***Planning Department
Transportation Development Services***

November 5, 2015

**Re: The Carlisle
3600 Central SE
Traffic Circulation Layout**
Engineer's/Architect's Stamp dated 11-1-15 (K17-D069)

Based upon the information provided in your submittal received 11-4-15, the above referenced plan cannot be approved for Building Permit until the following comments are addressed:

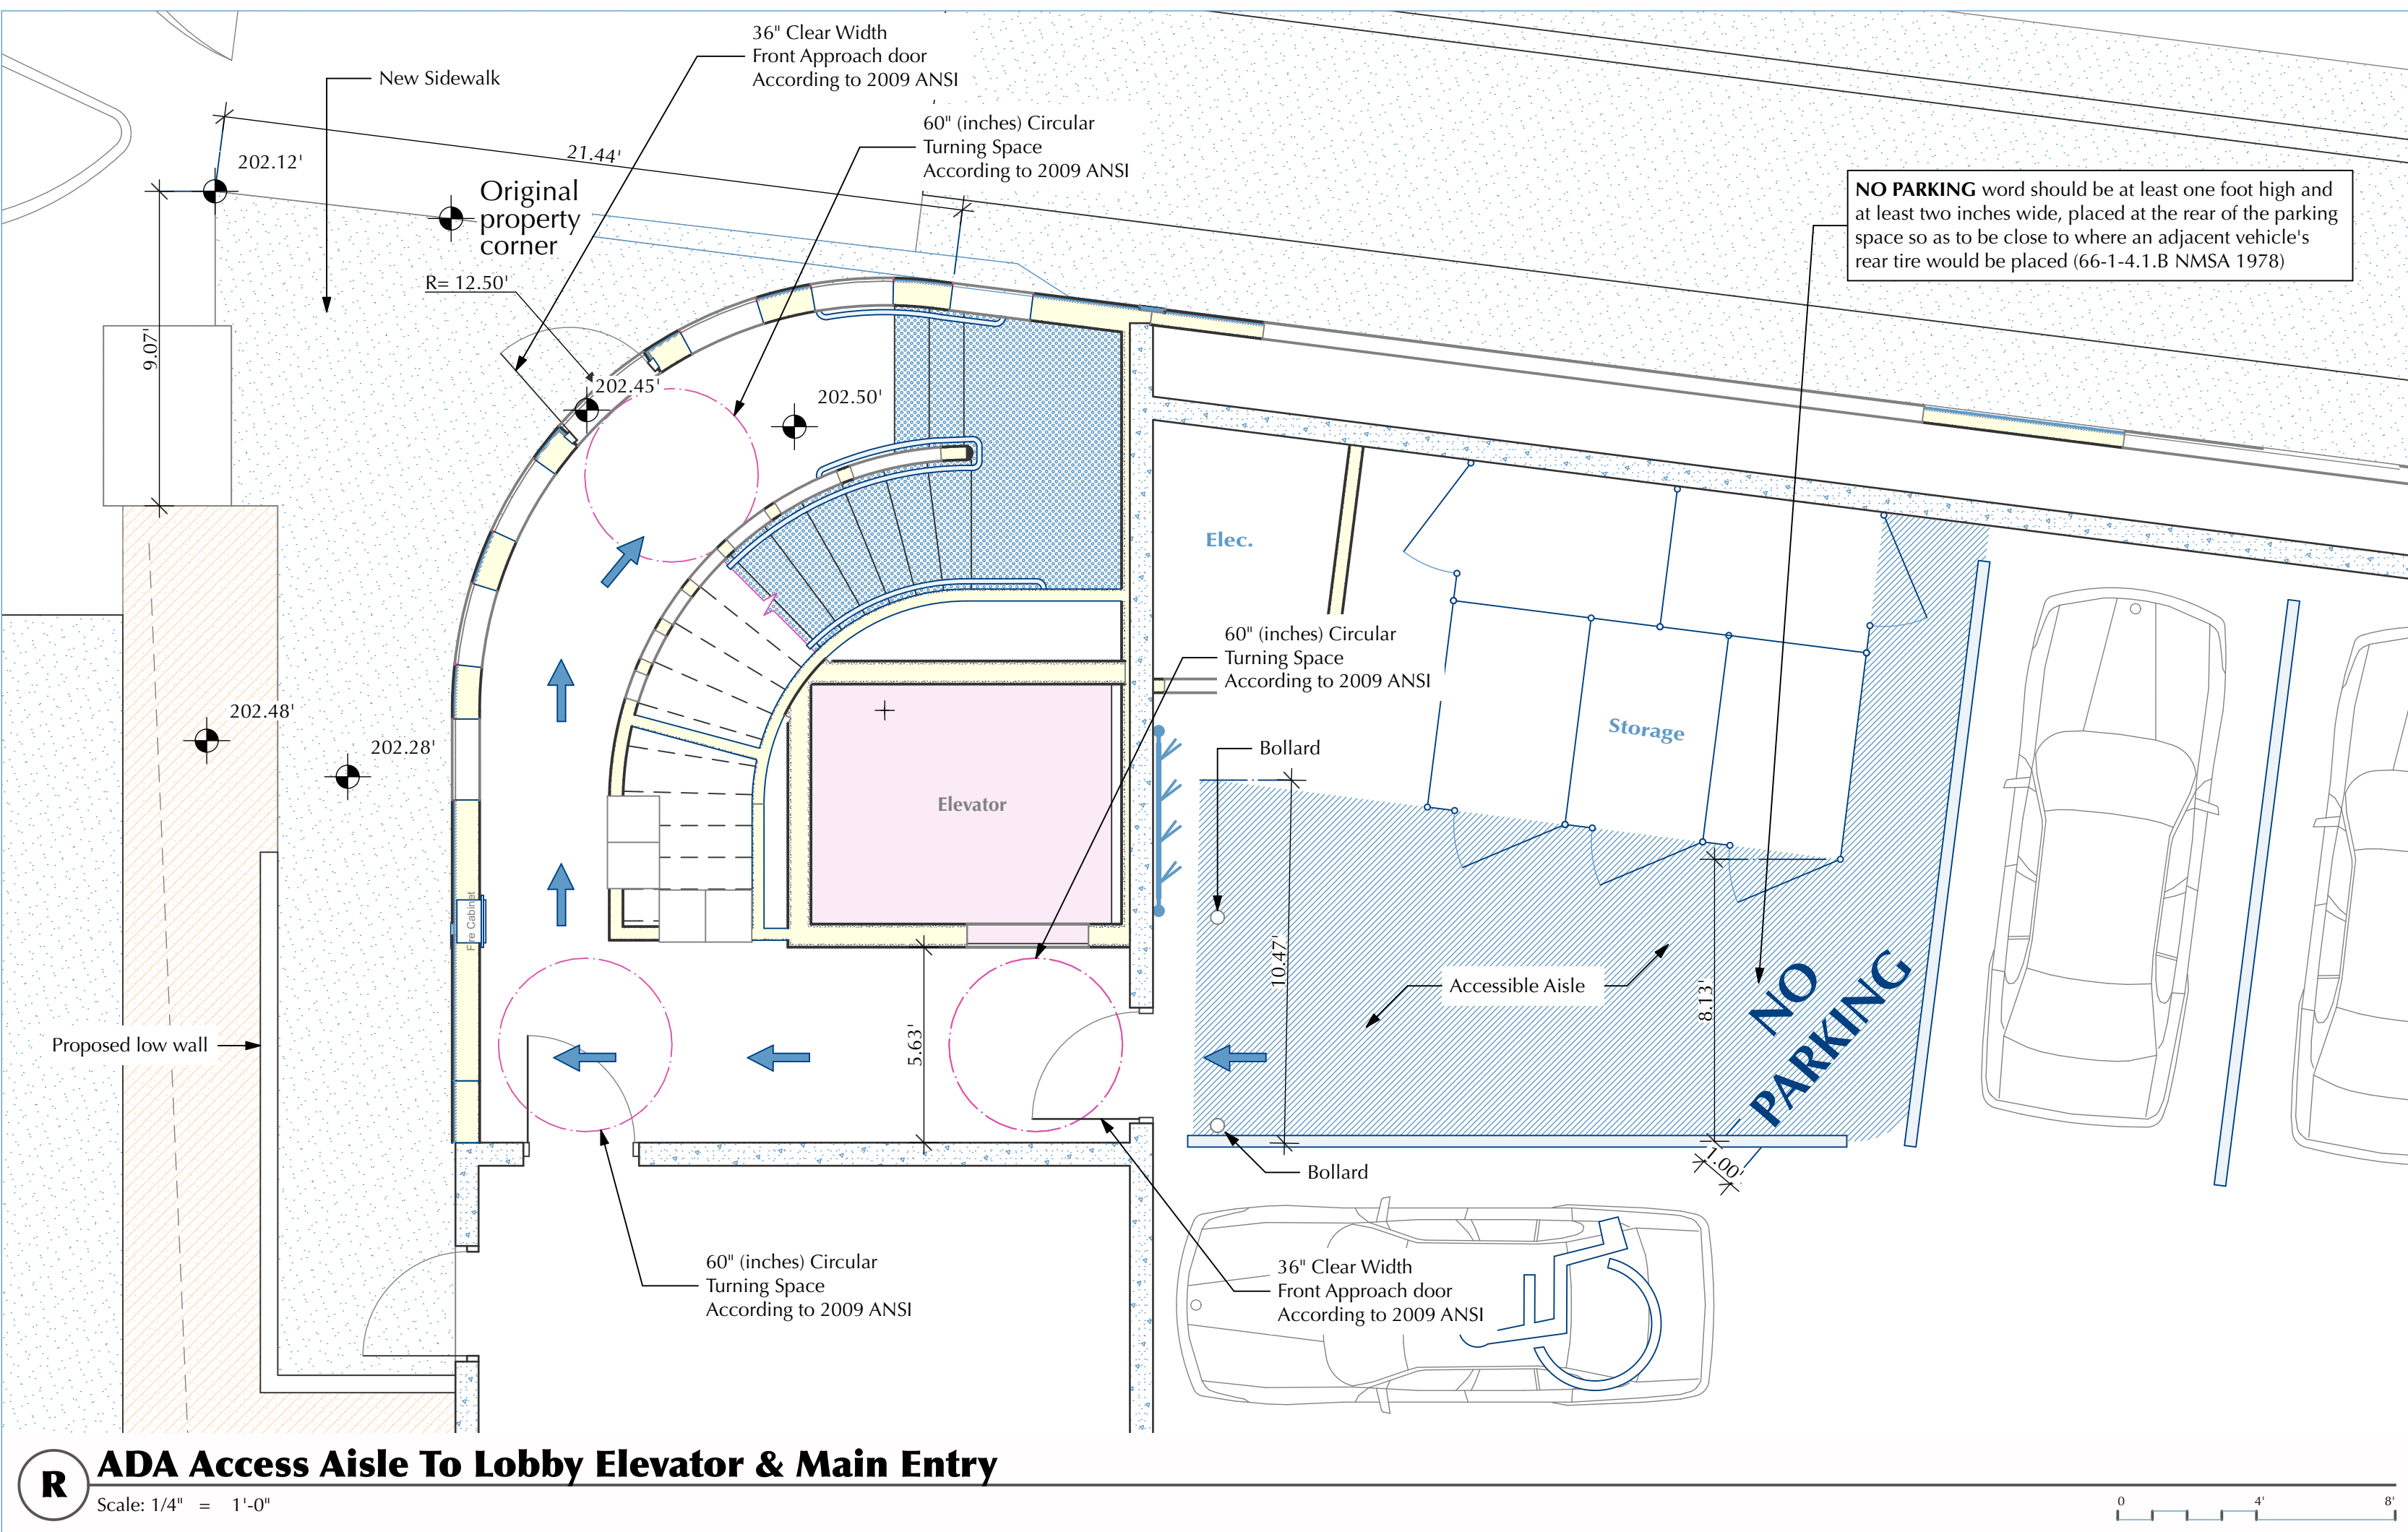
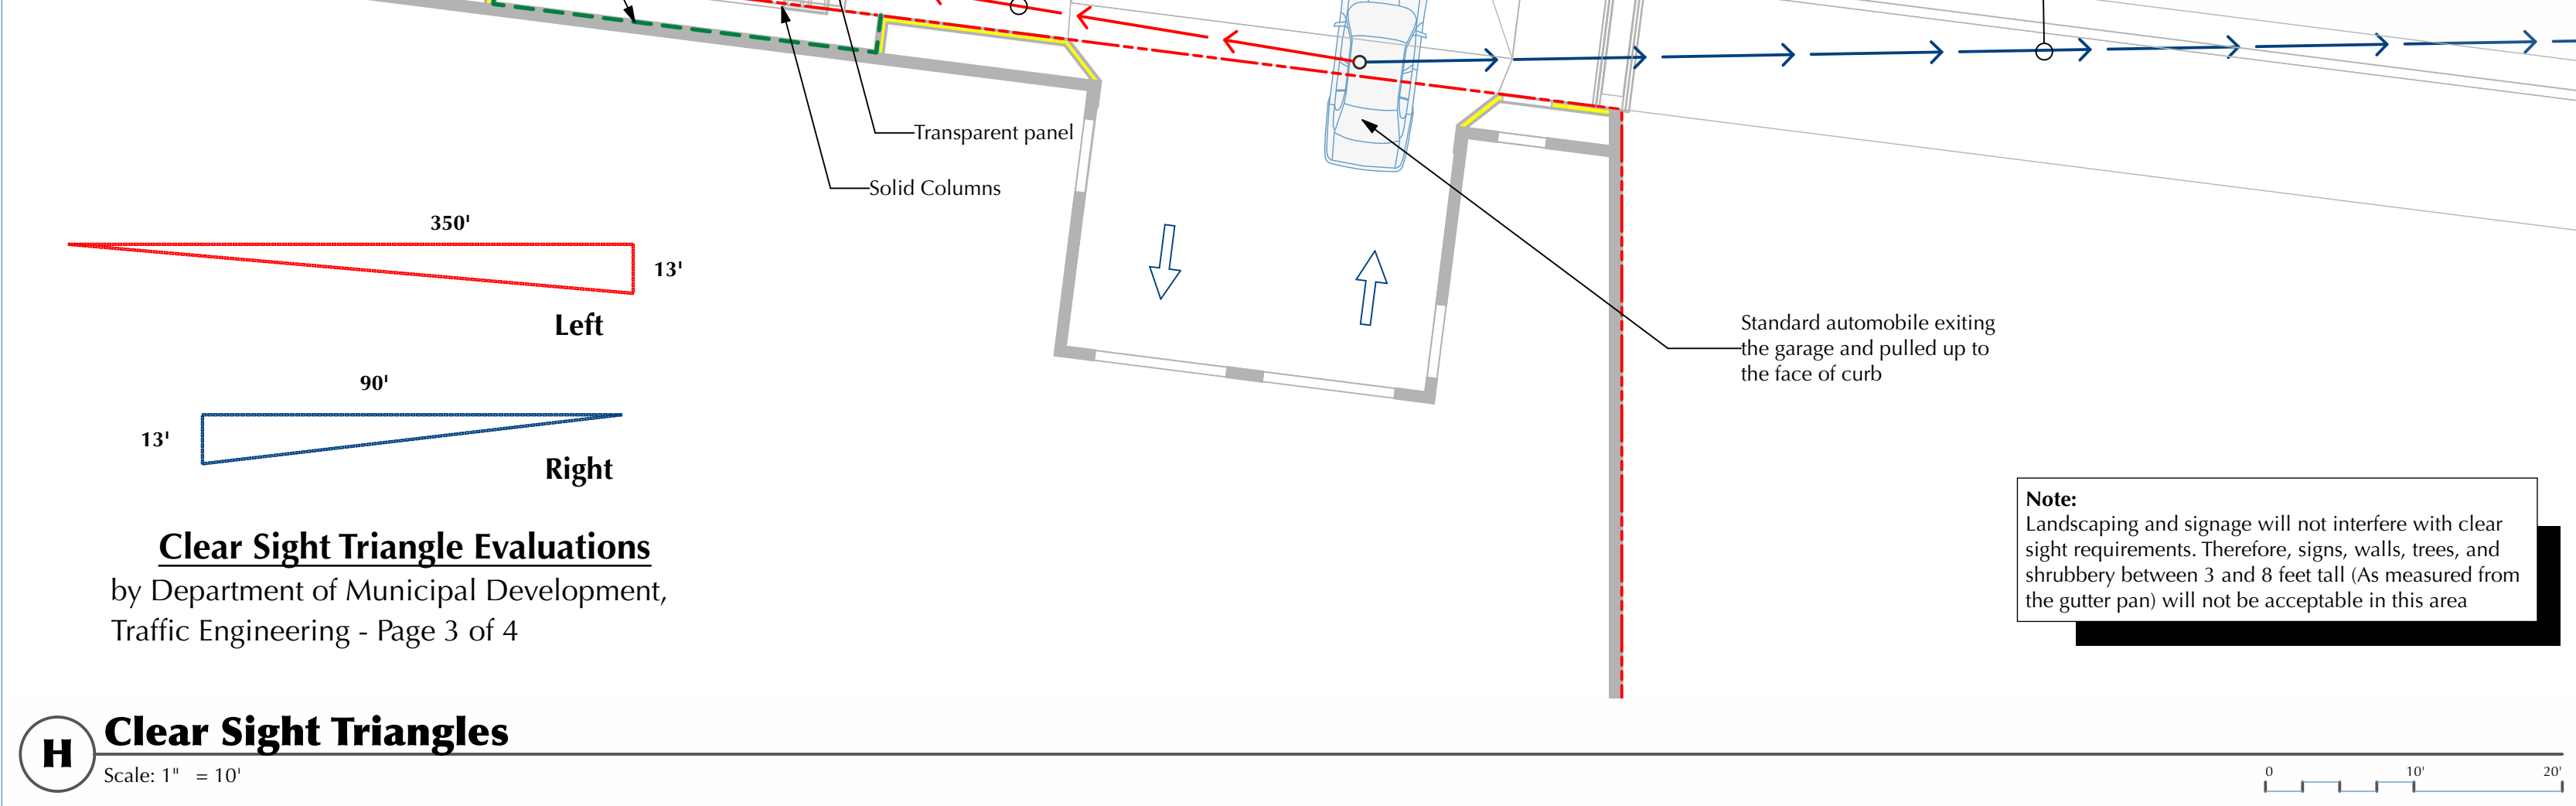
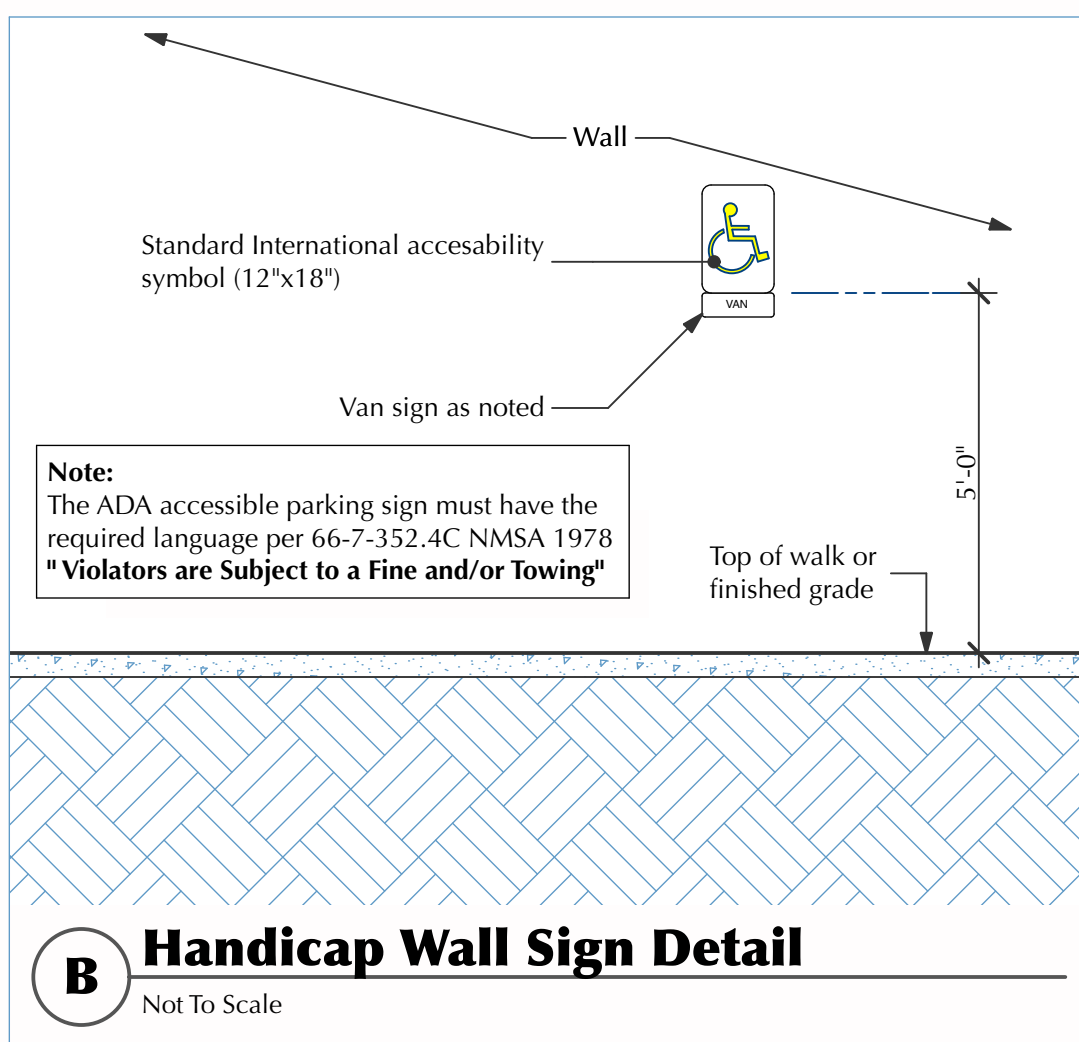
1. Please provide a sight distance exhibit signed and stamped by N.M. professional engineer.
2. Please add the following note to the clear sight triangle: "Landscaping and signage will not interfere with clear sight requirements. Therefore, signs, walls, trees, and shrubbery between 3 and 8 feet tall (as measured from the gutter pan) will not be acceptable in this area."

3. Please show a vicinity map showing the location of the development in relation to streets and well known landmarks.
4. Identify all existing access easements and rights of way with dimensions, including alley on the south side of proposed building.

5. Identify the right of way width, medians, curb cuts, and street widths on Carlisle Blvd., Central Ave. and public alley on the south side of proposed building.

6. The ADA accessible parking sign must have the required language per 66-7-352.4C NMSA 1978 **"Violators Are Subject to a Fine and/or Towing."** Please show a detail of ADA signage.

7. The ADA access aisle shall have the words **"NO PARKING"** in capital letters, each of which shall be at least one foot high and at least two inches wide, placed at the rear of the parking space so as to be close to where an adjacent vehicle's rear tire would be placed. (66-1-4.1.B NMSA 1978) Please clearly label the width of the ADA access aisle.

8. Per the DPM, a 6 ft. wide ADA accessible pedestrian pathway is required from the public sidewalk to the building entrances. Please clearly show this pathway and provide details, including slope details of pedestrian pathway to the building entrance.

9. Per the DPM, a 6 ft. wide ADA accessible pedestrian pathway is required from the HC parking stall access aisles to the building entrances. Please include details of ADA access to lobby and elevator.

10. Provide a min 6" or max 8" high concrete barrier curb or other acceptable barrier between landscaping and parking areas and/or drive aisles. Please detail barrier curb.

11. Design delivery vehicle route needs to be shown.
12. Service vehicle and/or refuse vehicle maneuvering must be contained on-site; provide a copy of refuse approval. Please clearly show location of refuse container.

13. Unused curb cuts must be replaced with sidewalk and curb & gutter. A build note must be provided referring to the appropriate City Standard drawing.
